The Member-Secretary,  
Madras Metropolitan  
Development Authority,  
No.8, Gandhi-Irwin Road,  
Egmore, Madras-600 008.

Lr.No.D.Dis.A1/1730/90

Sub: MMDA - Planning Permission - Construction  
of Residential building in Plot No.5  
at S.No.142/B and 141/B of Kodungaiyur  
village - Approval - Regarding.

SITE PLAN

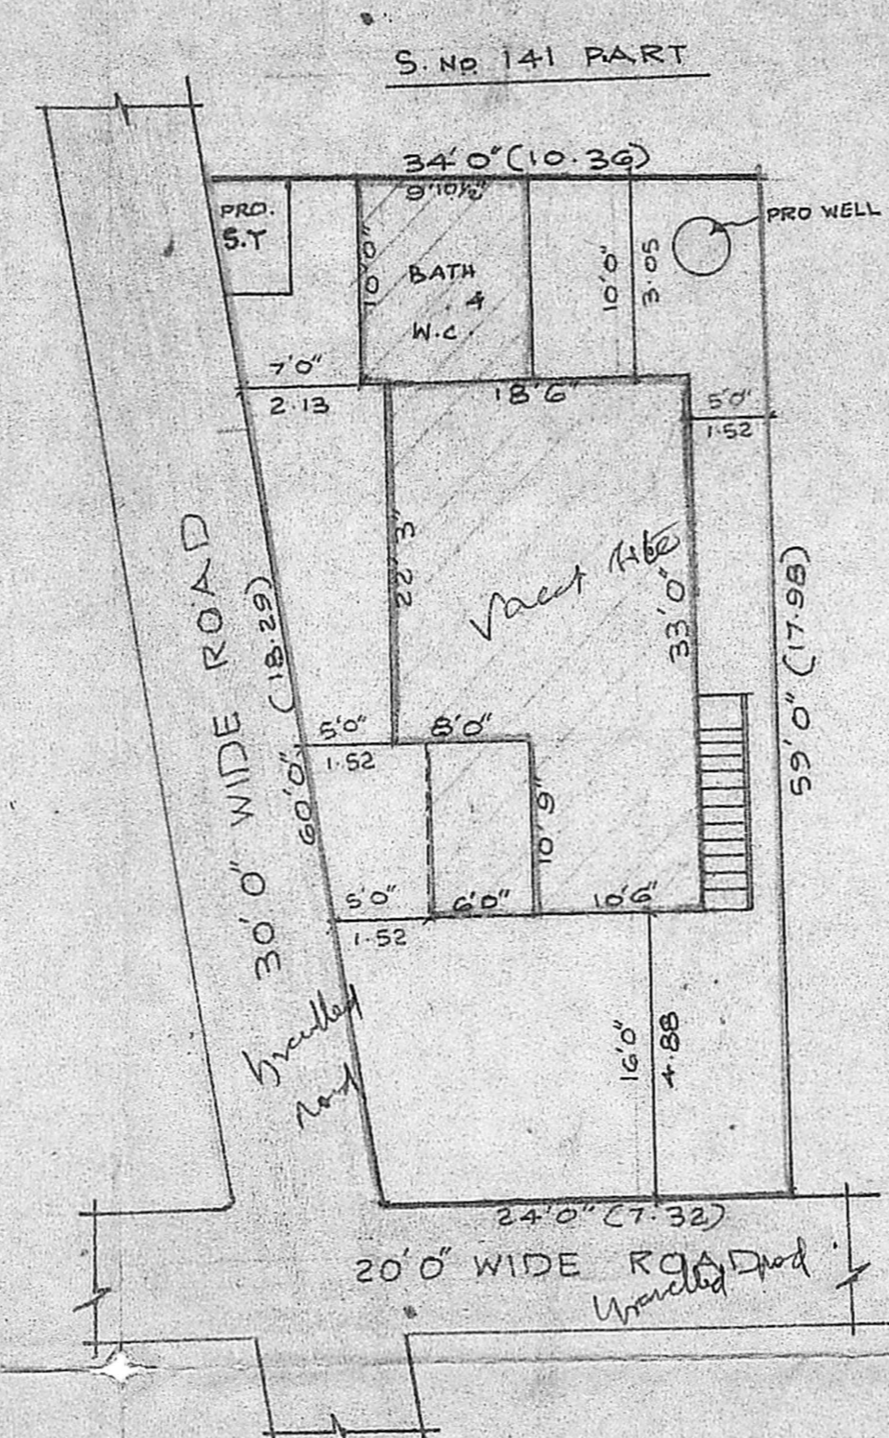
i) You are requested to issue Building permit after  
obtaining the revised plan showing the 3M x 3M as splay.
